St Anthony of Padua Catholic School Redevelopment (SSD-8865)
Request for Additional Information

I refer to Response to Submissions (RtS) for the St Anthony of Padua Catholic School Redevelopment (SSD-8865). After careful consideration, the Department is requesting that you submit additional information that effectively addresses the issues identified in **Attachment 1**.

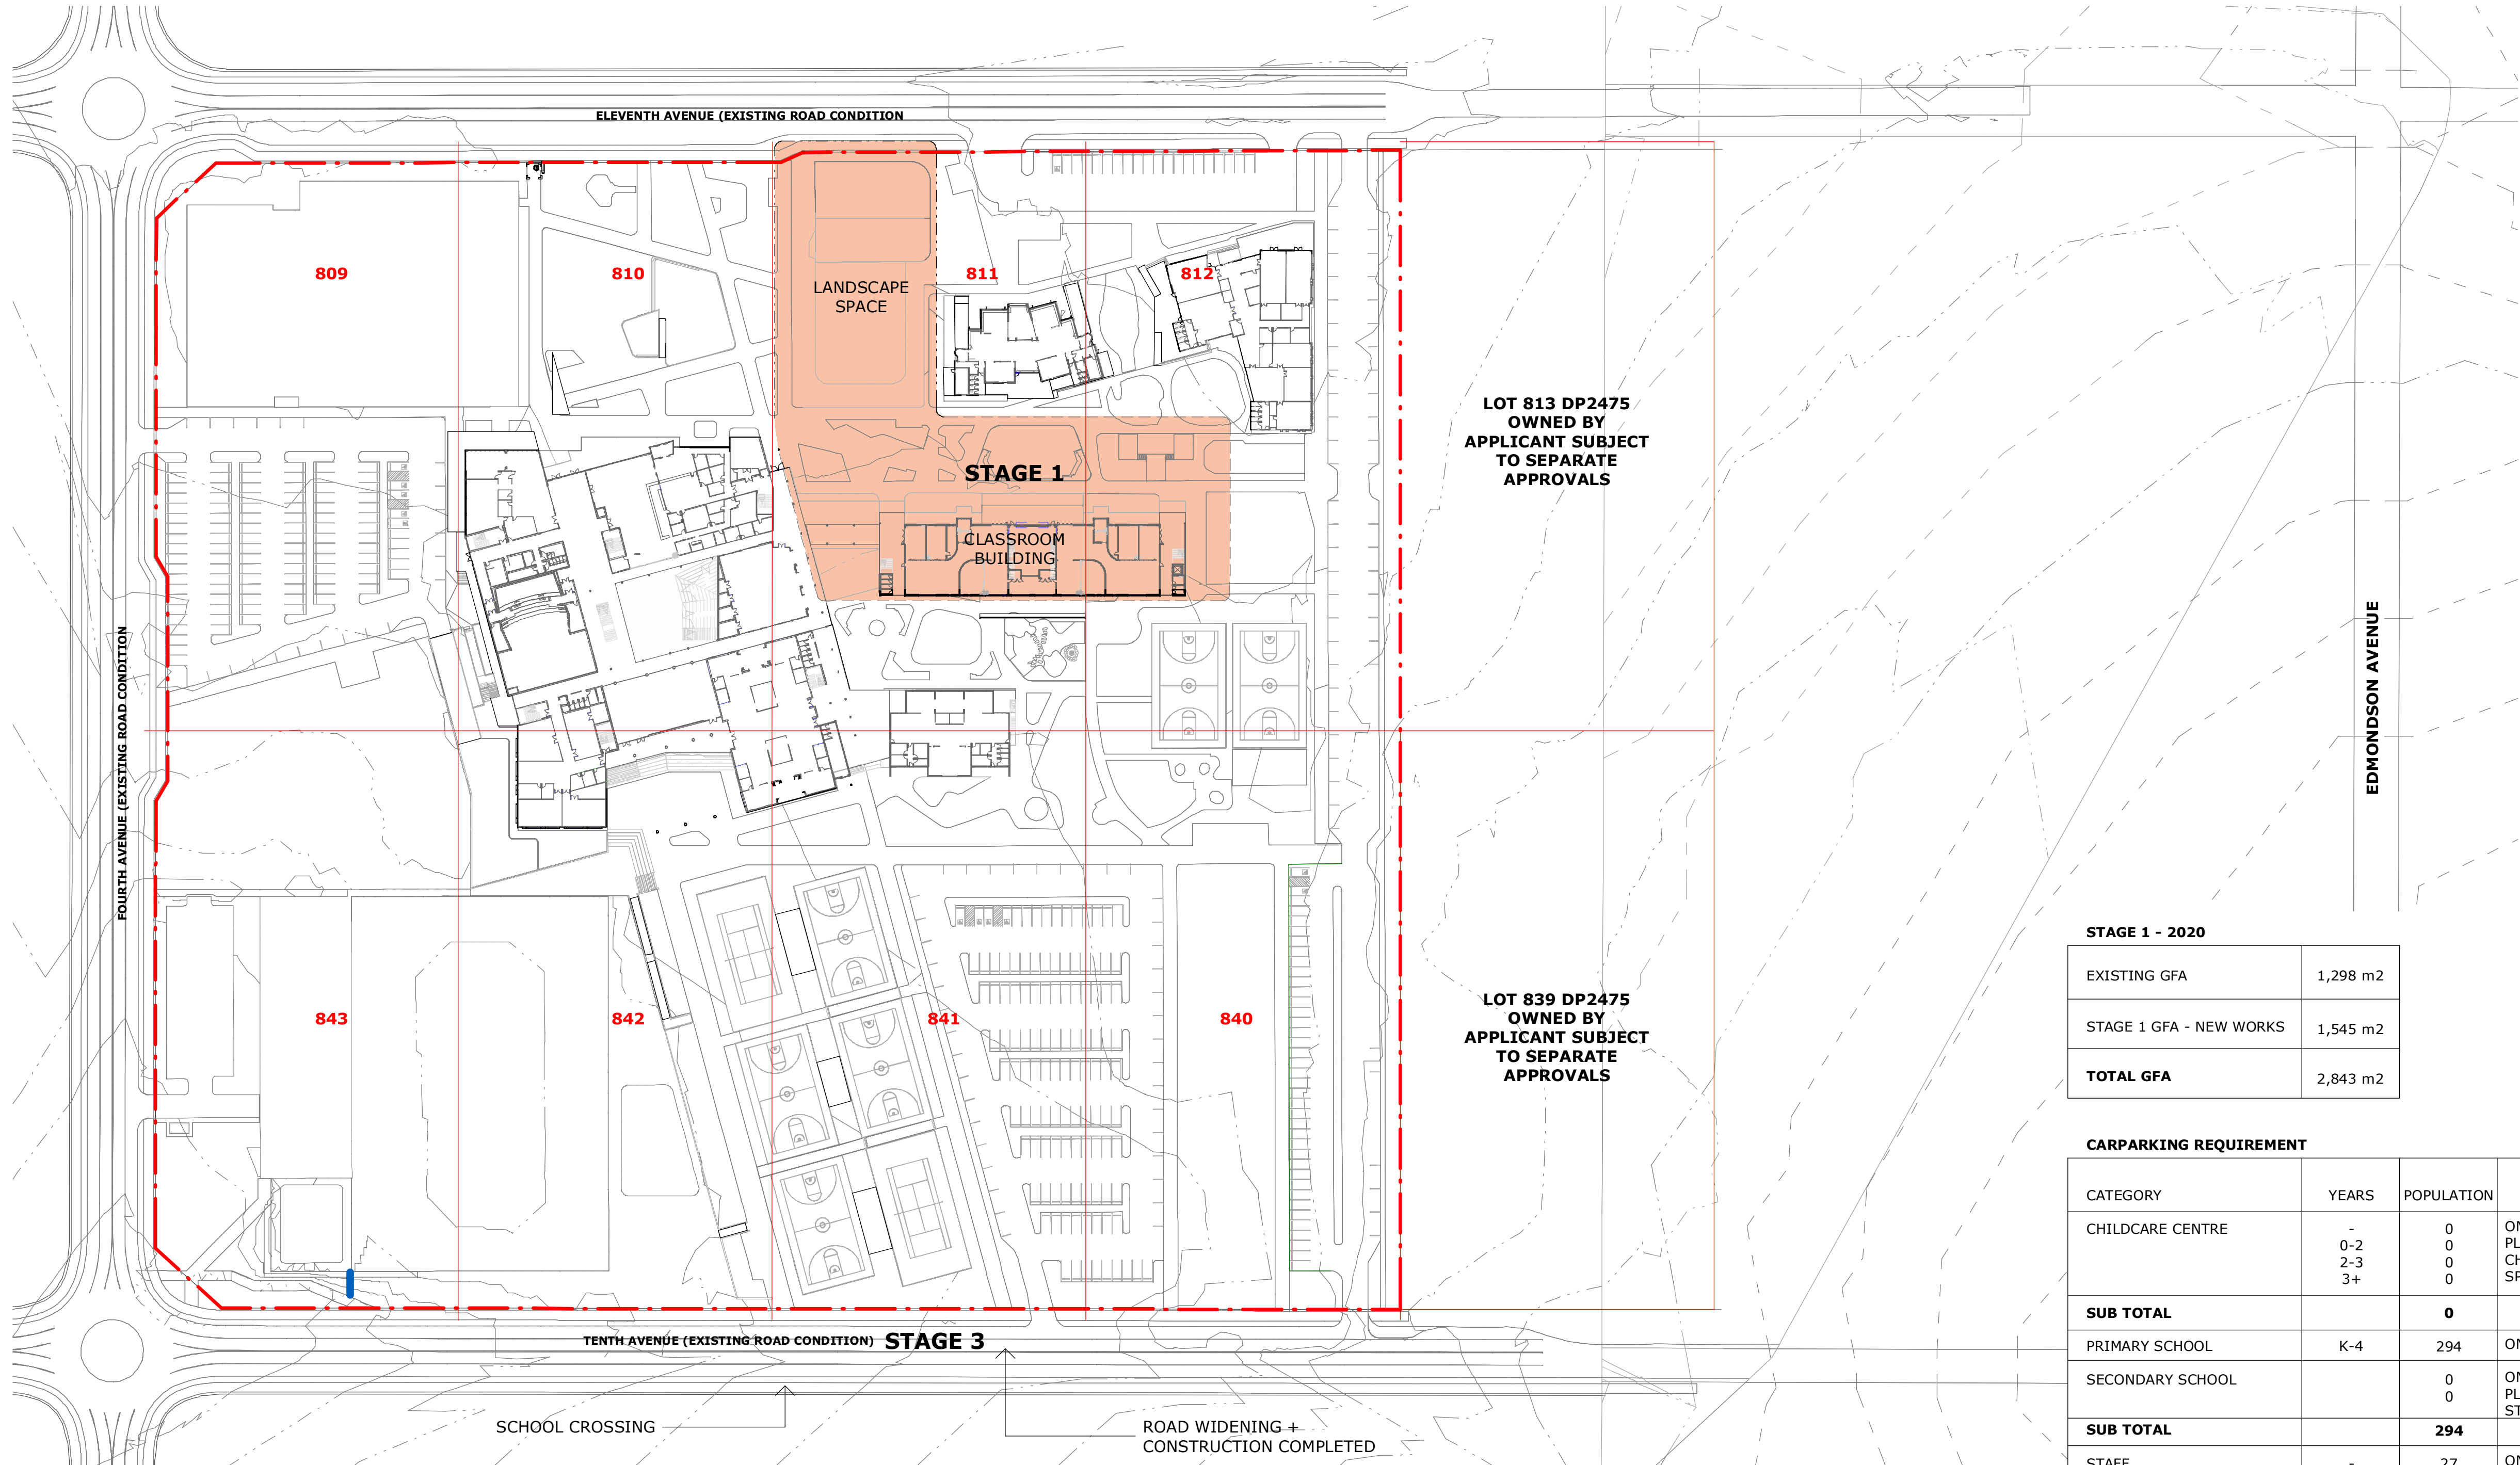
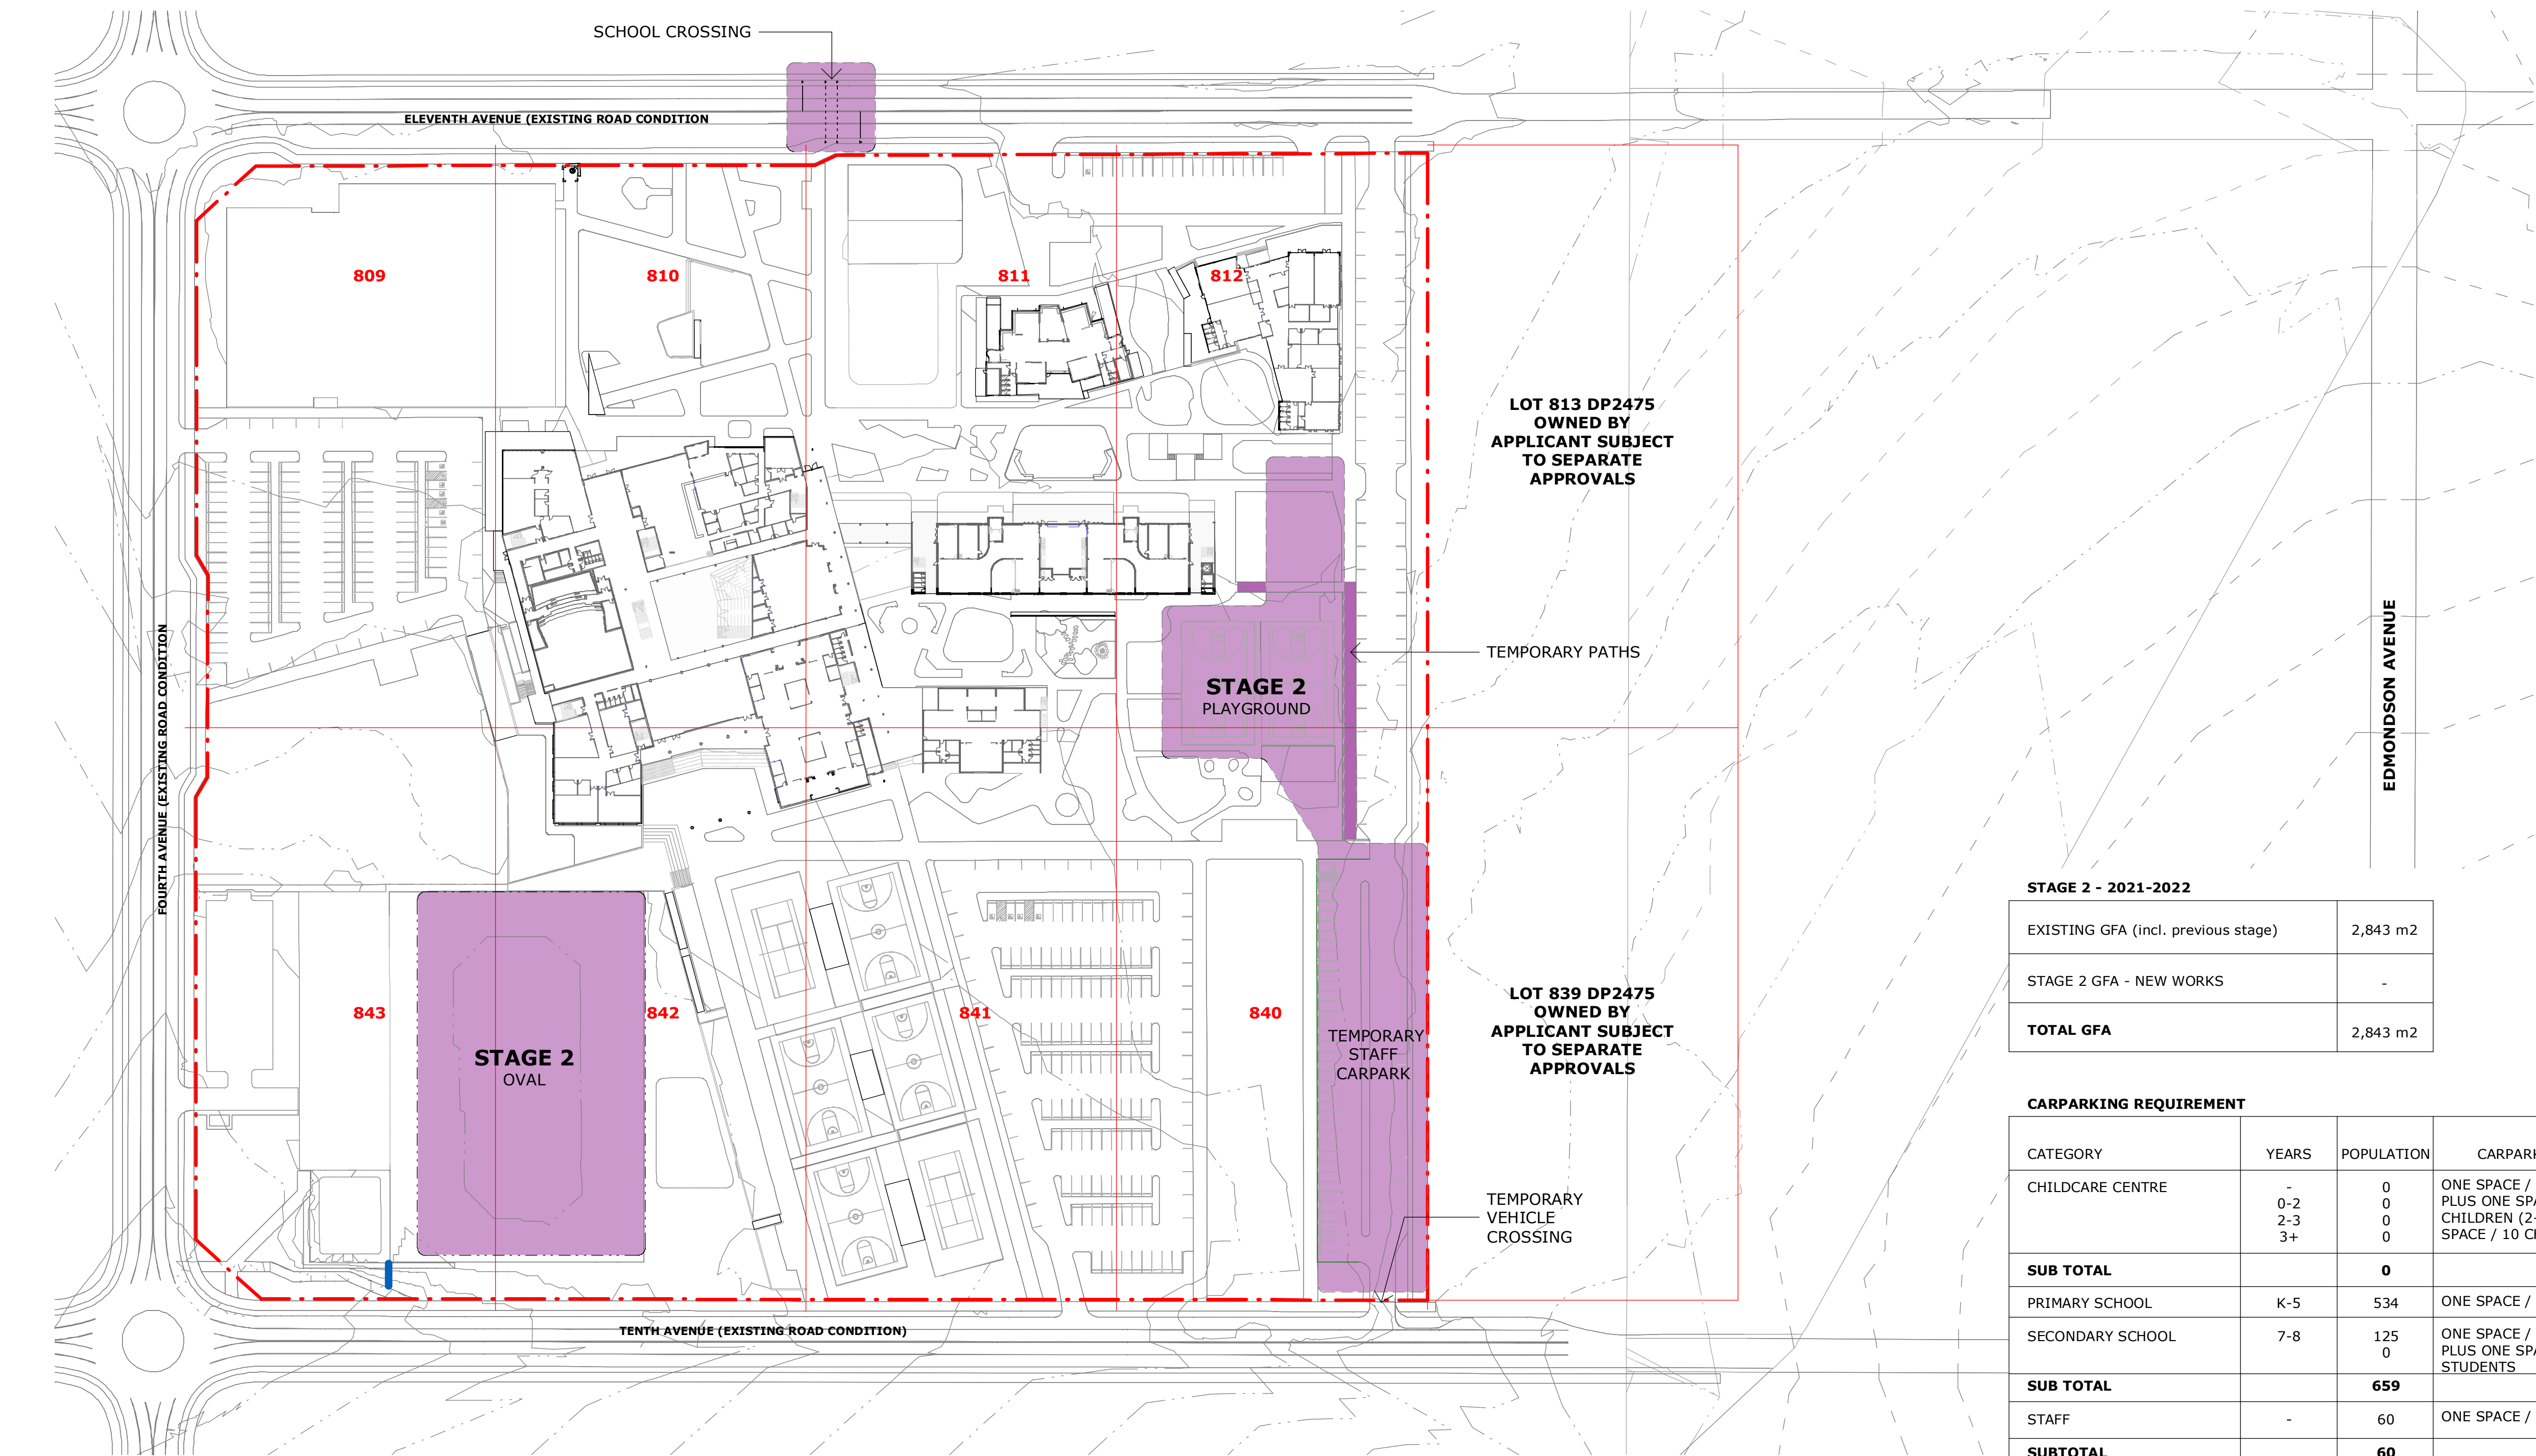
- a single (integrated) staging plan should be submitted that includes all construction stages in one plan.

- the central section of the eastern drop-off and pick-up area (on the internal road) and landscaping to the east of the central hub building have not been included in any of the construction stages. The Staging plans should be amended to include these works.

- the staging plans do not clarify whether the demolition works / remediation works tree removal would be undertaken prior to any works on the site or whether these works would also be undertaken in stages. Should these works be undertaken in stages, the following matters are required to be separately justified:

- the gross-floor area for each construction stage.
 - The correct number of car parking and drop-off and pick-up spaces for construction Stage 4 noting that the existing information is incorrect (177 car spaces) as it does not include the proposed 22 drop-off and pick-up spaces.
